Internal Ref: EXTERNAL/2024/0020

Inner West Council Response: SSD-76927247 – The Timberyards by RTL Co.

Property: Lots bound by Victoria Road, Sydenham Road, Farr Street and Mitchell Street, Marrickville NSW 2204

**2:00PM**

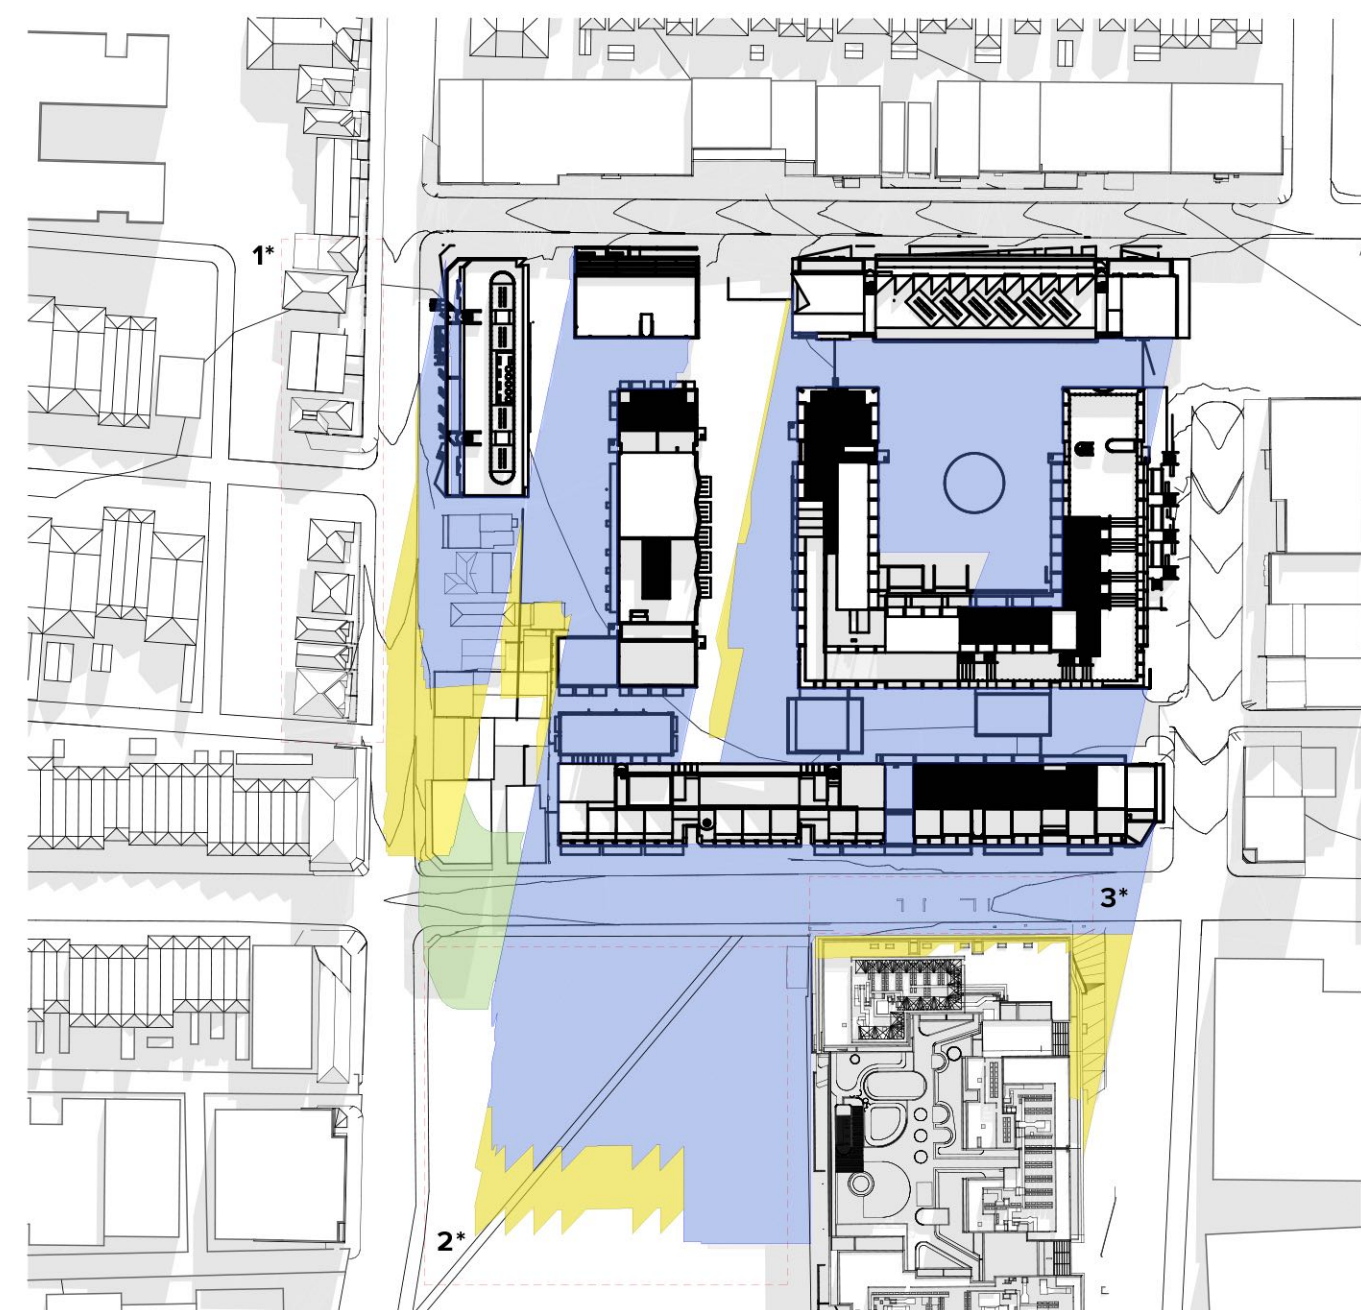
Shadow diagrams in plan view have been submitted, which demonstrate there is significant internal overshadowing within the site.

Based on the limited information provided, the shadow diagrams fail to demonstrate compliant solar access is received to the balconies and associated glazing which service principal living areas along all building elevations.

Furthermore, shadow diagrams in elevation view have not been submitted which demonstrate that the required 2 hours of solar access to the balconies and associated glazing which service principal living areas is achieved for;

- The southern elevation of all buildings;
- The eastern elevations of Buildings A, B, E, F & G; and
- The western elevations of Buildings B, D, E & G.

The current diagrams in plan view demonstrate that the northern elevations of the aforementioned buildings will receive solar access at only 3pm on June 21. The aforementioned eastern elevations receive solar access between 9am-10am, and thus only receive 1 hour of solar access between 9am and 3pm on June 21. The aforementioned western elevations receive solar access from 10am-11am, and thus only receive 1 hour of

solar access between 9am and 3pm on June 21. Given the above, it has not been demonstrated as to how the proposed living rooms and private open spaces of at least 70% of apartments on the site receive a minimum of 2 hours direct sunlight between 9am and 3pm in accordance with the design criteria under Objective 4A-1 of the ADG.
